**KIRKLEES METROPOLITAN COUNCIL
INVESTMENT & REGENERATION SERVICE**

Reference No:	2023/62/93279/E
Site Address:	1, Judy Haigh Lane, Thornhill Edge, Dewsbury, WF12 0QB
Description:	Erection of first floor side extension and alterations
Recommending Officer:	Edward Cheseldine

HOUSEHOLDER DELEGATED REPORT

GROUND FLOOR PLAN SCALE 1:100

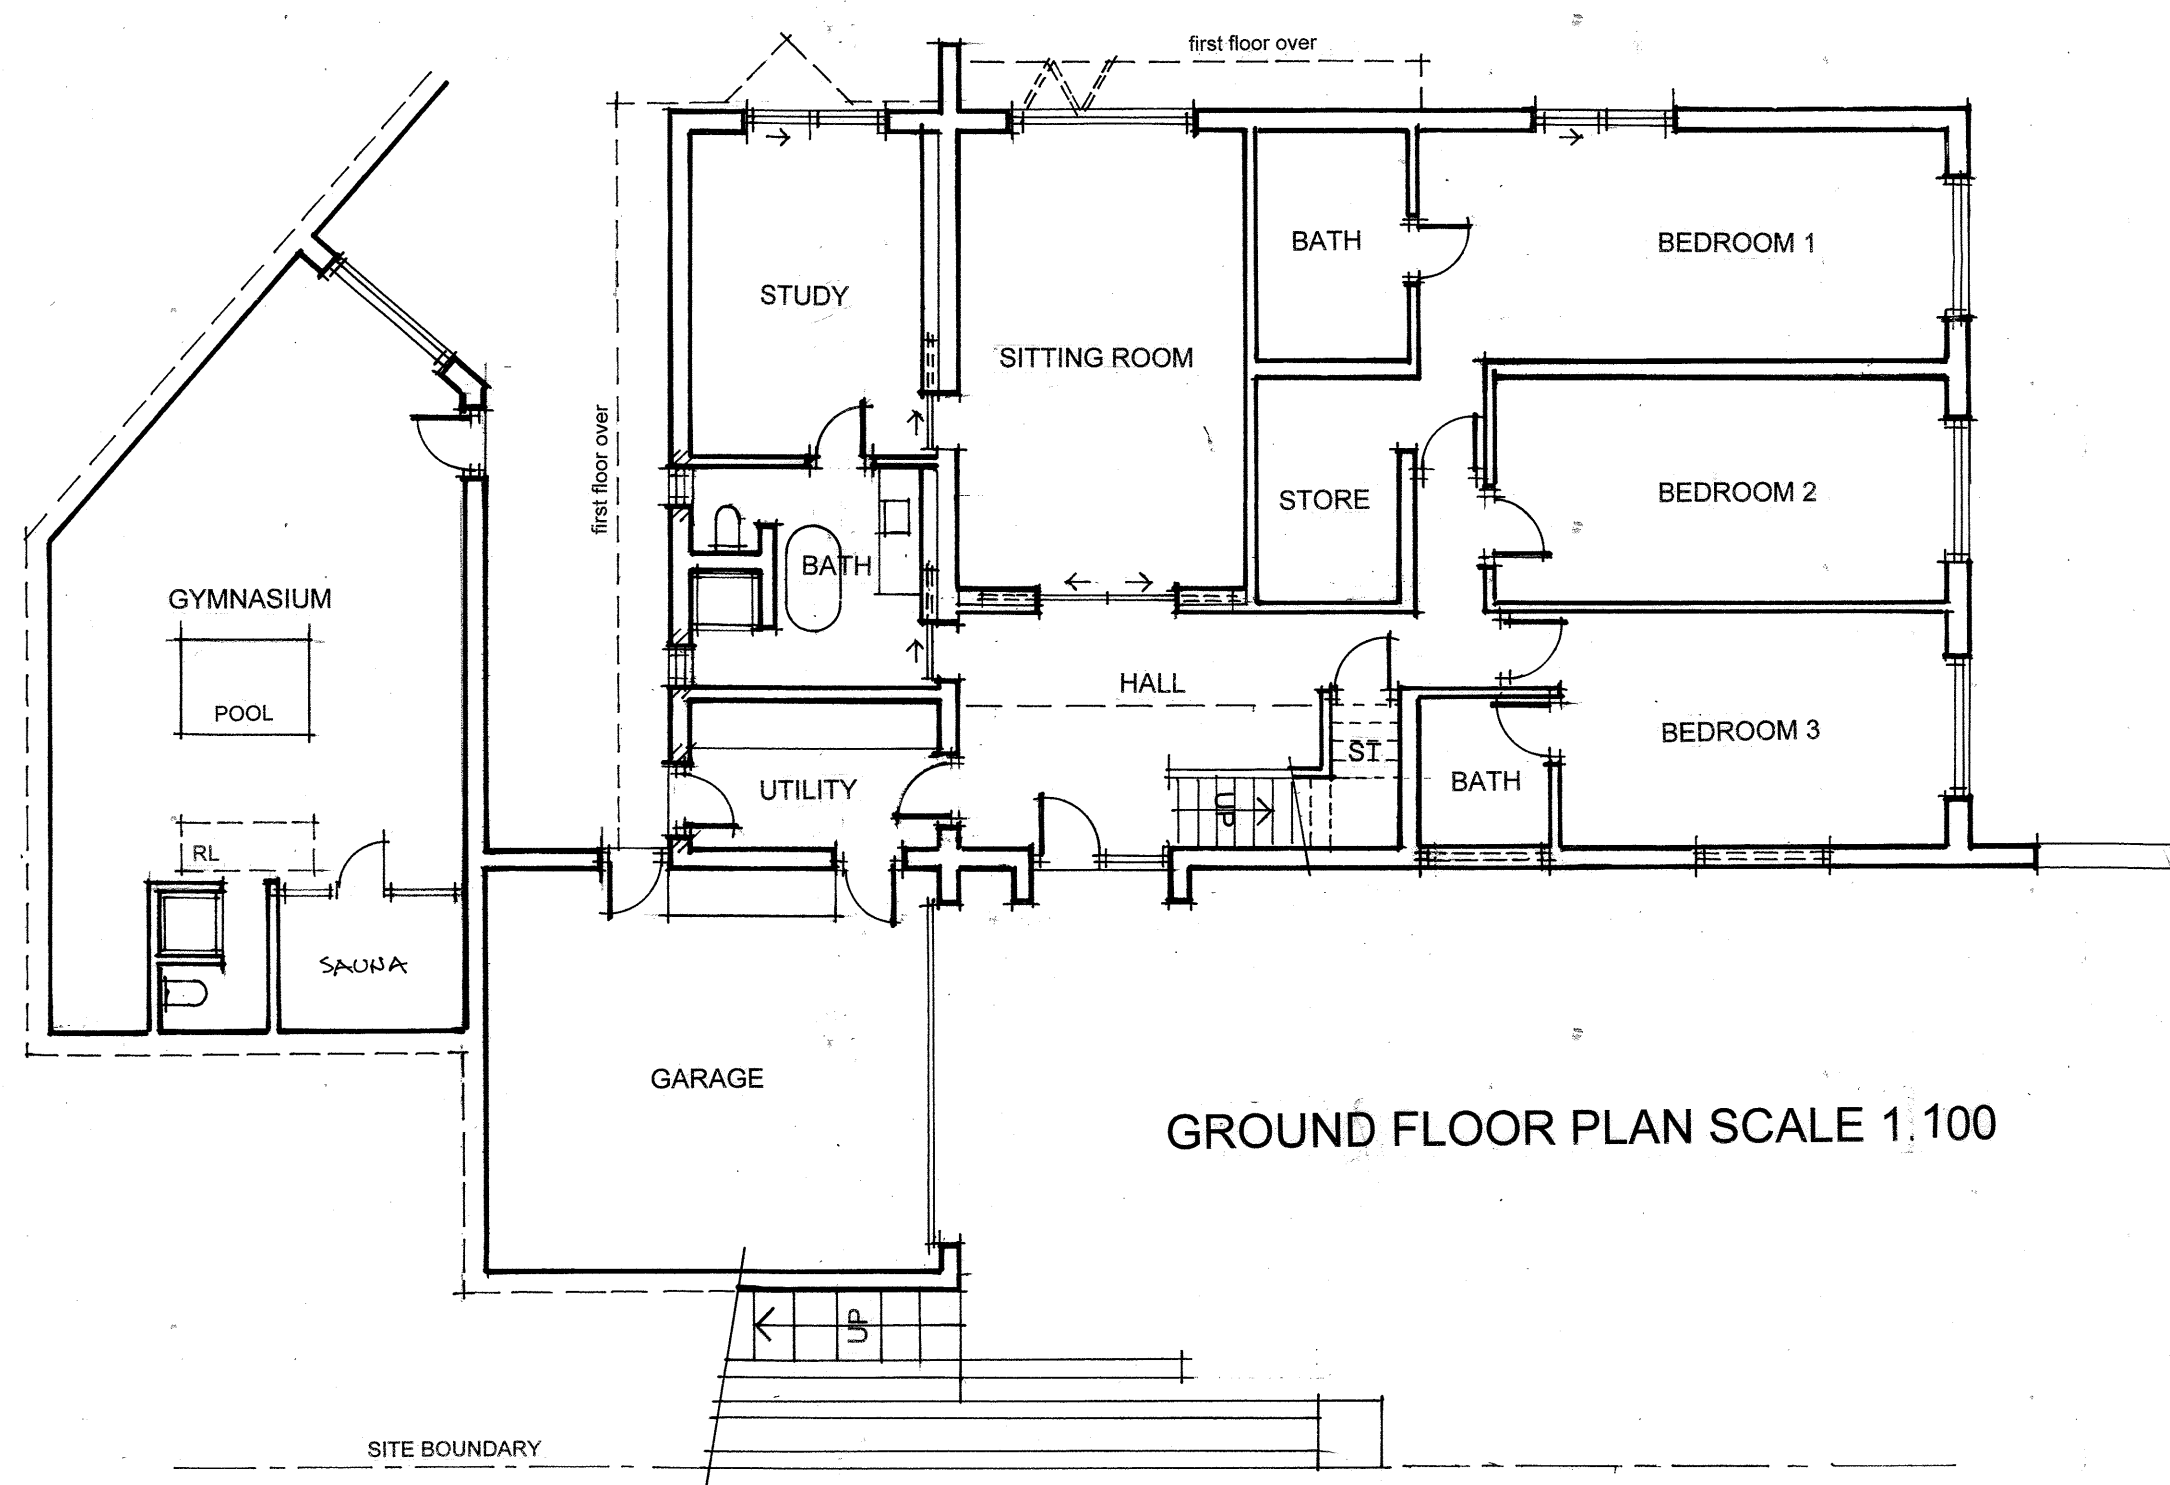
<u>Yes - COMPLY</u>	<u>No - JUSTIFY</u>
Not take up all or most of the space to the side of a house	Yes	
Maintain a 1 metre gap to the side boundary to ensure the building is not too close to a neighbouring property	Yes	
Be set back at least 500mm from the front wall of the house	No	The dwelling has a modern architectural design drawing on the use of rectangular shapes and right angles, denoting a 'Bauhaus' influence. In this instance, a 'set back' approach would harm the original character of the dwelling by deviating from the angular form of the original house .

Impact on light and outlook of neighbours (to sides, rear and front)	• KDP 4, 5, 6 of the SPD • Policy LP24 Design (b) • Chapter 12 of the NPPF	As there is a subsection to the ground floor section of the building, the height of the two-storey element will be ~2.80m from ground level at a distance of ~2.20m to the shared boundary.	✓

Due to the height above ground level of the two-storey element and distance to the boundary, there will not be a loss of light. The distance from the side windows will mitigate a loss of outlook. A window is proposed to light a W/C area. In order to protect from privacy, it will be conditioned that this window is obscurely glazed.	
--	--	--	--

3. The extension shall not be occupied until the W/C window in the side elevation of the extension hereby approved has been obscurely glazed (to a minimum Grade 4). Notwithstanding the provisions of the Town and Country Planning (General Permitted Development) Order 2015 as amended (or any Order revoking or re-enacting that Order) the obscure glazing (to a Grade 4) shall thereafter be retained.
